Wilpshire Parish Council

Planning application 3/2012/0001 6A Somerset Avenue, Wilpshire

Client	Mr and Mrs Smith	
Job Title	Proposed Alterations	
	Tryfan	
	Somerset Avenue	
	Wiltshire	
Drawing Title	Proposed Plans and Elevations	
Scale	Date	Drawn
1:100	DEC 2011	DL

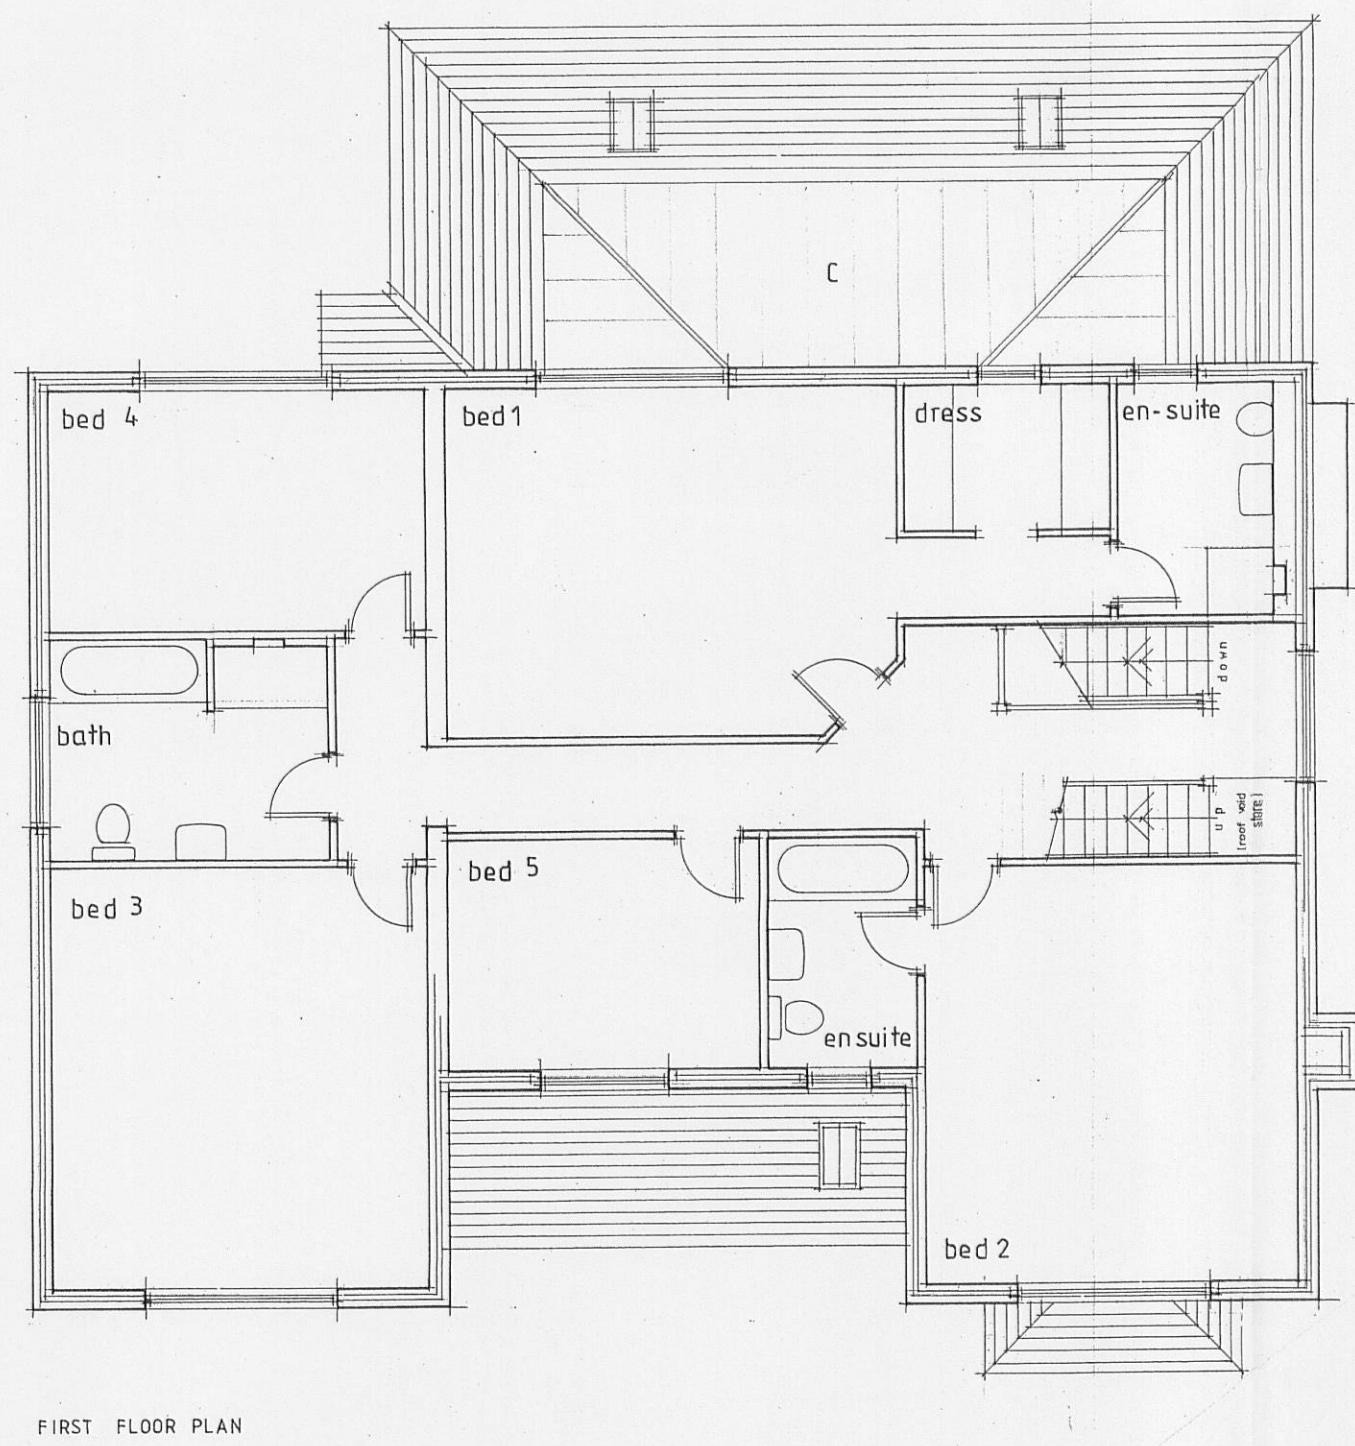
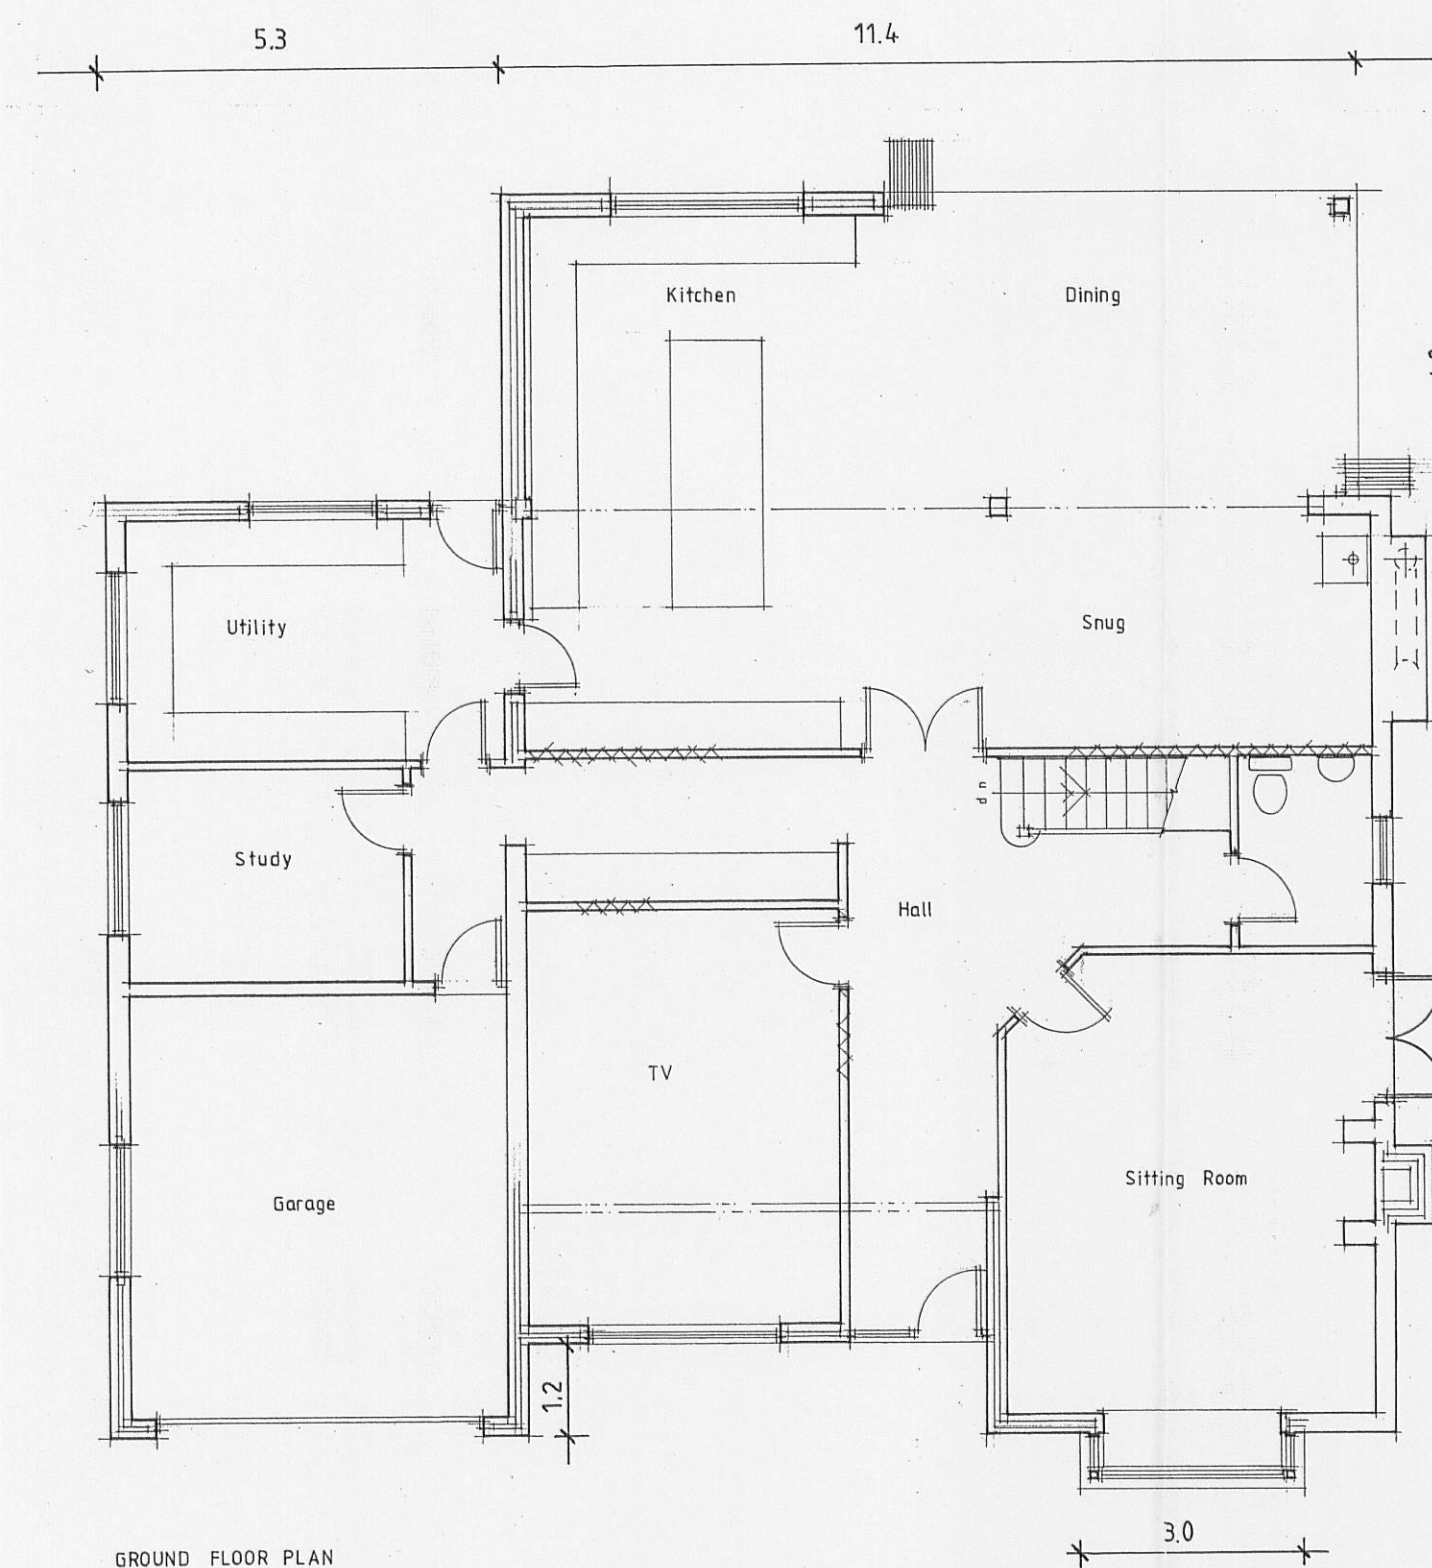
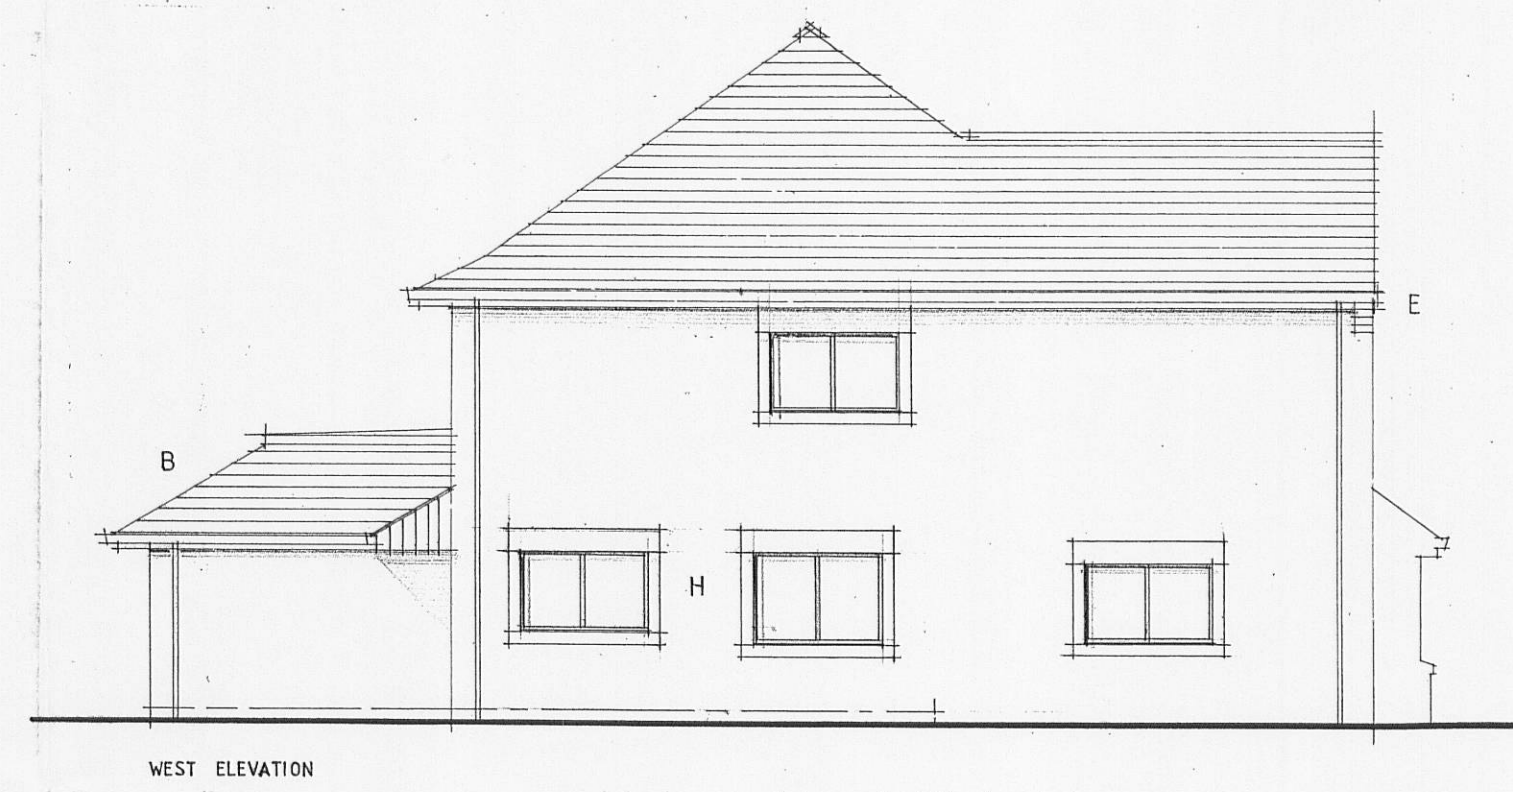
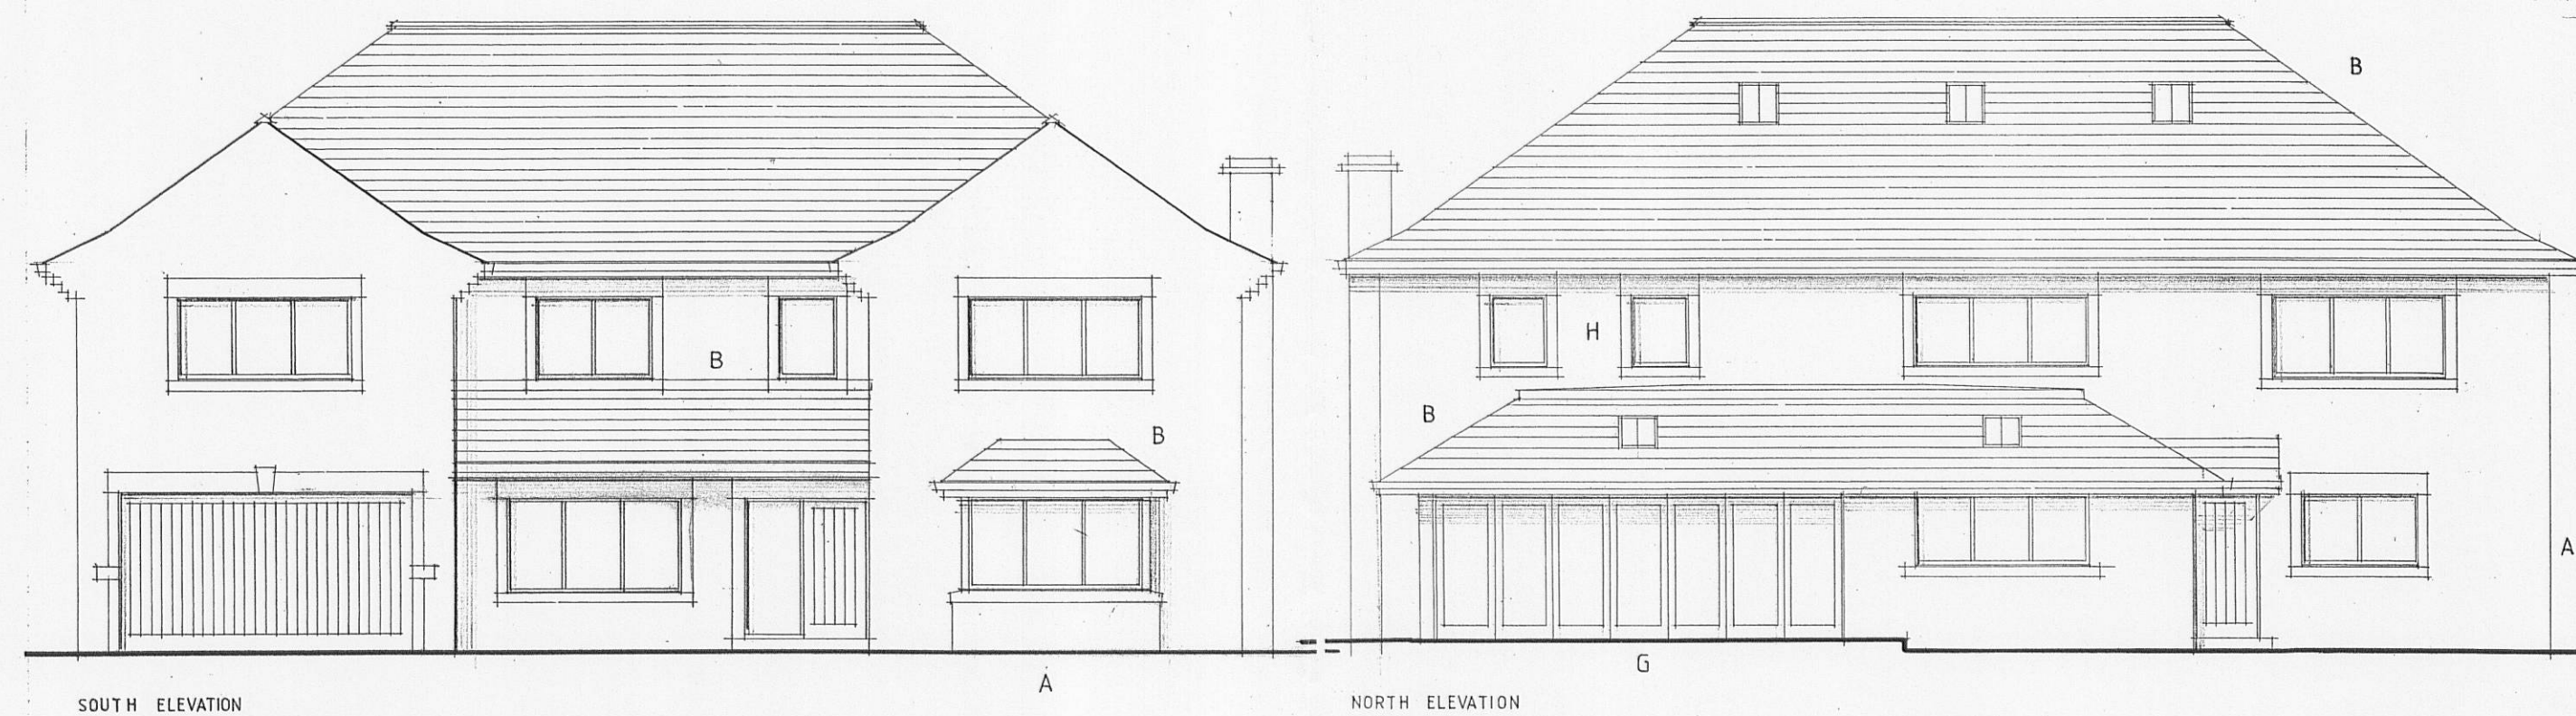
It is a large development.

from the end and rear of Vicarage Lane, and for no 28 in particular. For no 28 there are possible issues of loss of light, though the planned development is to the East from the rear of Somerset Ave., the proposed roof line is significantly higher than the row of existing houses on Vicarage Lane.

Privacy: There will be some overlook of the rear of 8 Somerset Ave, the crown of existing trees has been lifted so that the proposed new windows at first floor level will not be screened.
